Lime Down

Solar Park

Hydrology, Flood Risk and Drainage Response to LLFA Comment WC-053 Raised in Deadline 2 Submissions

Document Reference: EXAM/9.47

Title:
Figure 11.1 Rev3 : Lime Down A Fluvial and
Surface Water Flood Risk Map

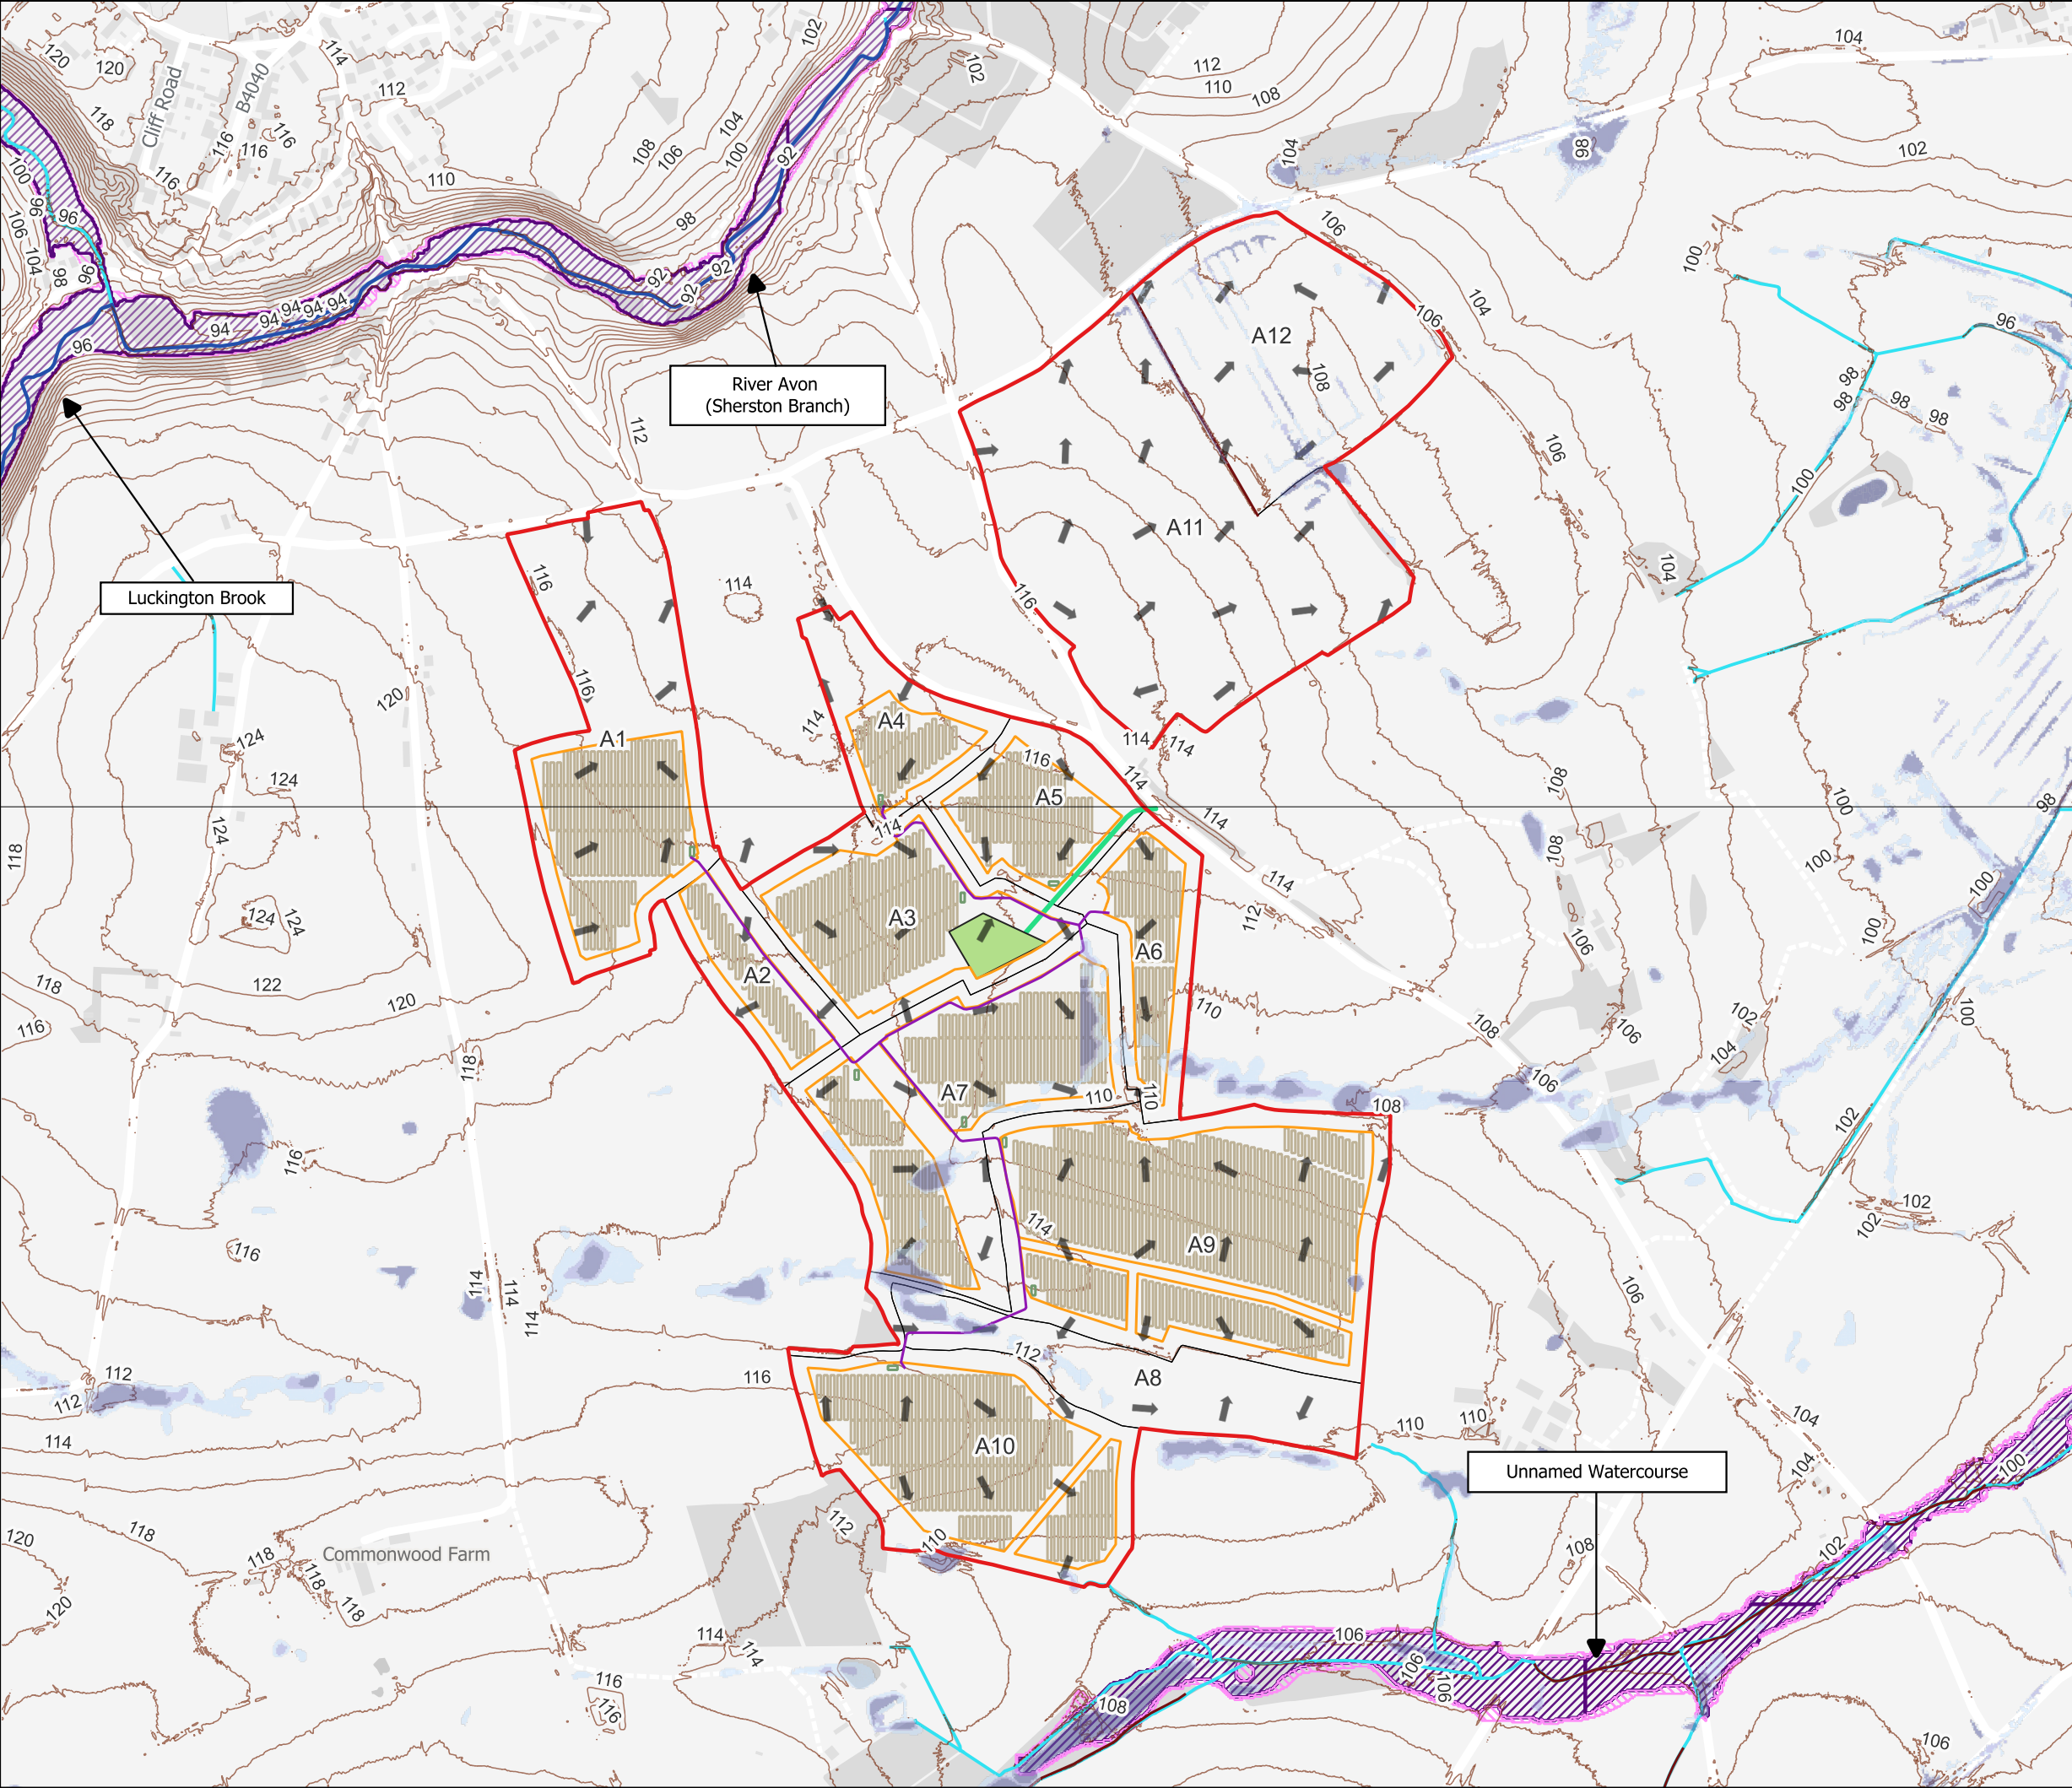
1.5 Comment 5: Exceedance flow routing is not consistently demonstrated across the Scheme.

1.17 Comment 17: The absence of mapped exceedance pathways reduces confidence.

- 1.5.3 The relevant **ES Volume 2, Figures 11-1 to 11-7: Fluvial and Surface Water Flood Risk Maps [REP3-027 to REP3-033]** and site-specific drainage sections will be updated to show existing drainage features, mapped surface water pathways and exceedance principles more clearly.

- 1.17.1 The Applicant's response to FHW1.3 in the **Applicant's Response to the Examining Authority's First Written Questions [REP3-128]** confirms that the relevant flood risk figures and site-specific drainage sections will be updated to show mapped surface water flow routes, drainage features, indicative drainage zones and exceedance principles where relevant.
- 1.17.2 The final exceedance routes for formal drainage systems will be confirmed through detailed design under Requirement 11 of the **Draft Development Consent Order [REP3-005]**.
